CHAIN VALLEY COLLIERY – MODIFICATION 1

Response to Submissions

Section 96 Modification to SSD-5465

Prepared for LakeCoal Pty Limited
September 2014

**Figure 2:** Proposed underground linkage between Chain Valley and Mannering collieries

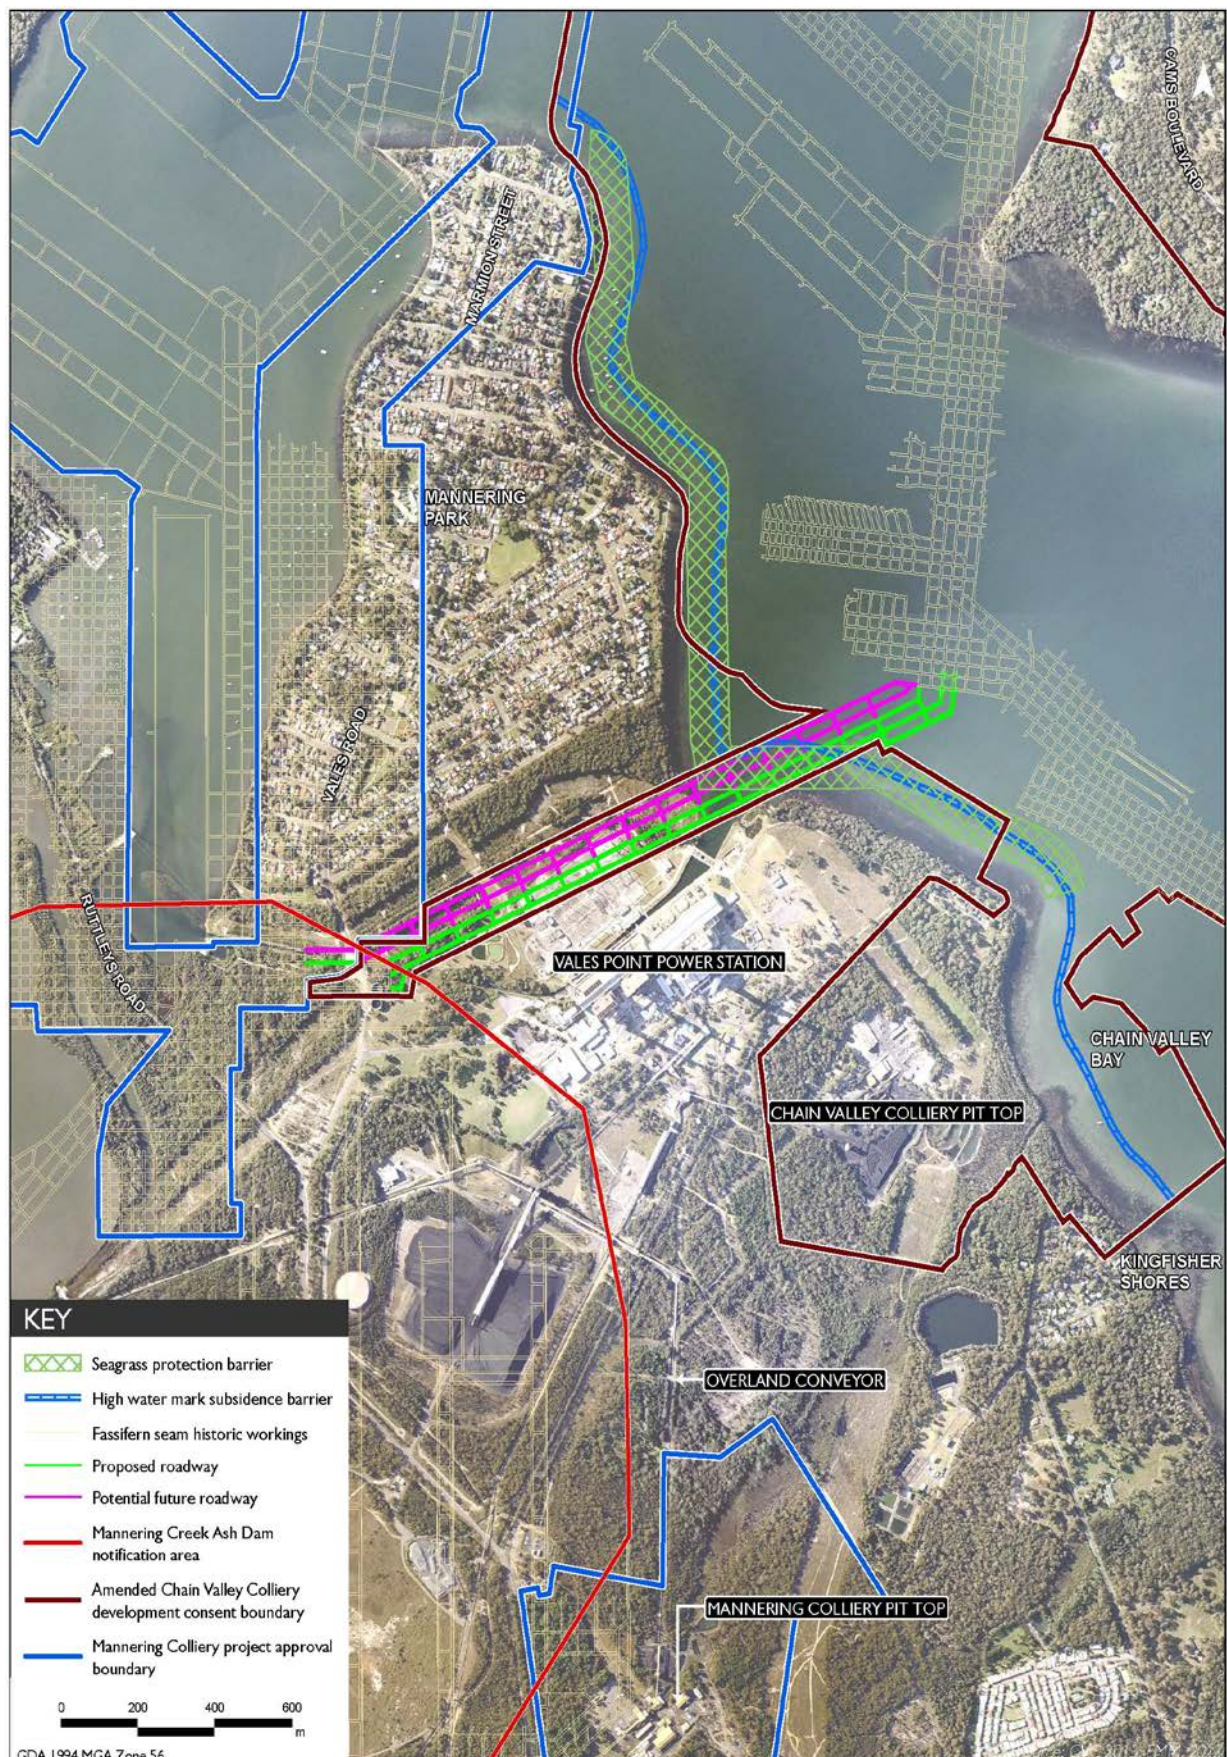
TransGrid	<p>TransGrid’s Vales Point 330kV substation and four 330kV transmissions lines (No. 22, No. 23, No. 24 and No. 92) are located above the proposed modification.</p> <p>The modification must not put at risk the safe, reliable and efficient continued operation and maintenance of TransGrid’s electricity network.</p>	<p>Transgrid’s infrastructure was identified as a significant built feature during the planning phase for the proposed modification and, accordingly, was an important consideration in the design of the underground linkage. The subsidence assessment completed a detailed assessment of potential impacts on this infrastructure. The independent peer review, Appendix D, also provided a focus on the potential impacts of the proposed modification on this infrastructure.</p> <p>LakeCoal fully appreciates the importance of this infrastructure. As described above, the infrastructure was considered during the detailed design process, subsidence assessment presented in the SEE and independent peer review.</p> <p>The subsidence assessment concludes the proposed first workings are unlikely to impact on the transmission towers and switchyard. The peer review concludes that the proposed mining does not cause a credible threat to the future stability and serviceability of the TransGrid assets.</p>

Submission by	Comment summary	Response
	<p>The existing transmission towers and the Vales Point substation have not been designed or constructed to allow for any tolerance from subsidence impacts.</p> <p>Exposure to these impacts would result in potential long term damage to TransGrid’s Vales Point substation and transmissions towers. This is likely to affect the safe operation of those assets and result in potential failure and outages of the high-voltage electricity network (i.e. blackouts).</p> <p>It is unprecedented that any sub-surface development has been permitted to adjoin or encroach on any of TransGrid’s substation infrastructure.</p>	<p>As described above, subsidence from the proposed modification does not cause a credible threat to the future stability and serviceability of the TransGrid assets.</p> <p>As stated in the independent peer review:</p> <p>In their submission dated 14th August 2014 TransGrid note that “<i>the existing transmission towers and the Vales Point sub-station have not been designed or constructed to allow for any tolerance from subsidence impacts</i>”. Whilst this is taken as factual, it is inevitably the case that those structures have been designed to include levels of design conservatism consistent with their critical importance to the electricity supply network that they support. Therefore it must surely also be the case that they are able to accommodate some level of disturbance due to mining subsidence without inevitably resulting in “<i>long-term damage to TransGrid’s Vales Point sub-station and approximately 21 transmission towers</i>”.</p> <p>As a final comment, in any cases whereby underground coal mining was to include substantial secondary extraction in close proximity to such electricity network infrastructure, the author would inevitably conclude that the infrastructure not having been designed to accommodate mining subsidence impacts was a fatal flaw and that consequently such mining would indeed represent a major threat to its continued stability and serviceability. However in this particular instance whereby the type of mining being contemplated is limited to highly stable first workings only, the author is compelled to conclude that the infrastructure not being designed for mining subsidence impacts does not in any way automatically result in a credible threat to its future stability and serviceability.</p> <p>Mining beneath the Vales Point substation previously occurred in the Great Northern Seam as identified in the subsidence assessment. Mining was undertaken by Powercoal, a wholly owned subsidiary of Pacific Power, a State Owned Corporation established under the Electricity (Pacific Power) Act 1950 (NSW).</p>

Submission by	Comment summary	Response
	<p>TransGrid considers that the proposed modification would place unacceptable risk on the safe, reliable and efficient continued operation and maintenance of TransGrid's high voltage electricity network and requests that the alignment of the proposed workings be reconsidered to avoid undermining the Vales Point substation and minimising the number of transmission towers undermined.</p> <p>TransGrid requests a copy of the peer review of the subsidence assessment and would appreciate ongoing consultation about the project.</p>	<p>As described above, the proposed modification does not cause a credible threat to the future stability and serviceability of the TransGrid assets. Therefore, it is not considered appropriate to reconsider the alignment of the proposed underground linkage.</p> <p>A copy of the independent peer review is attached as Appendix D and was provided to Transgrid on 29 August 2014. No formal comment from TransGrid subsequent to receipt of the independent peer review has been received.</p>

Figure 3: Proposed linkage in relation to existing workings and surface features

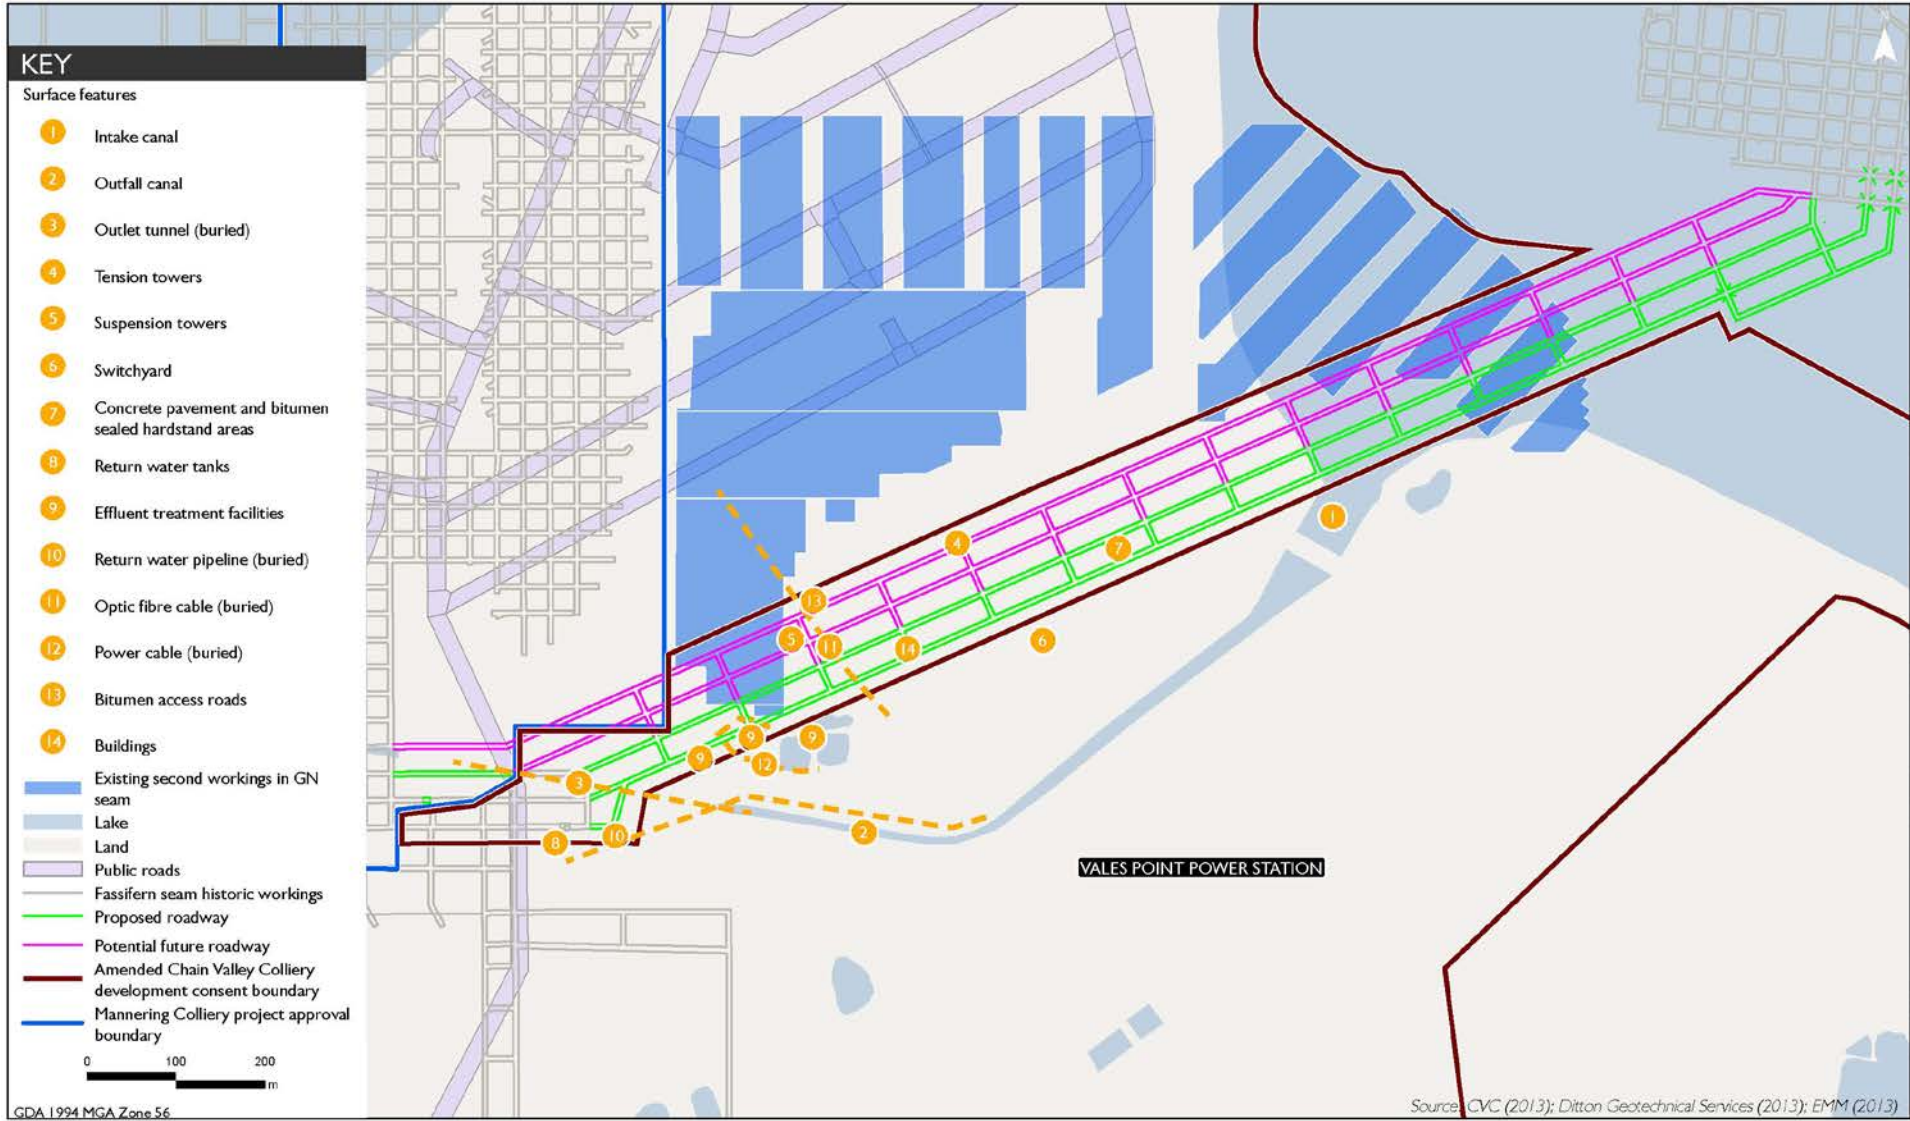
<p>LMCC states that it is desirable to reduce subsidence in the vicinity of the lake foreshore as much as possible and contends that there is little or no discussion in the assessment provided of the need or justification for the additional northern roadways.</p> <p>It notes that the direct and cumulative effect of subsidence could be reduced by withholding approval for the additional roadways, particularly as the cumulative impacts are biased towards the northern side of the development as a result of the existing workings.</p>	<p>The Laxton letter concludes that a subsidence of 20 mm is highly unlikely to have any measurable effect on this remaining vegetation. It is noted that up to 5 mm of subsidence is predicted in this area from the proposed modification.</p> <p>The mine design, which is limited solely to first workings, is cognisant of the importance of limiting subsidence in the vicinity of the foreshore. Accordingly, the subsidence assessment specifically modelled subsidence from mine workings in the Great Northern Seam, associated with the former Wyee State Mine, to ensure worst case impacts were able to be assessed, despite this earlier subsidence occurring approximately 20 years prior.</p> <p>As identified in Section 3.2.1 of the SEE, the two northern roadways, while not planned to be developed initially, would permit a significant improvement in ventilation flows between the Collieries. The additional roadways would also provide flexibility in ventilation management and redundancy in the event of equipment failure, extended maintenance or in an emergency situation. Although the additional roadways have no specific commencement date, by identifying and assessing the impacts for the four roadways in the current application, not two, significant efficiencies will be realised for LakeCoal, regulators and other stakeholders in the longer term, while also being transparent about potential longer term first workings in the area.</p>

Submission by	Comment summary	Response
		<p>Regarding the cumulative impacts being biased to the northern side of the development, the cumulative subsidence in this area is largely a result of the previous secondary extraction that was undertaken in the 1970s in the Great Northern Seam. Subsidence resulting from the proposed modification (i.e. the development of all four roadways) would generally be less than 20 mm or ‘zero’.</p> <p>As per Table 6.1 of the SEE, LakeCoal was committed to “Complete representative borehole core drilling and sampling of the Fassifern Seam floor at the start and finishing ends of the underground linkage and where the headings pass beneath the SPB. Development below the foreshore will be limited to two headings only until floor conditions can be confirmed.” This commitment is reiterated in the revised statement of commitments (Appendix C).</p> <p>It is considered that there is no reason for withholding approval of the additional roadways.</p>
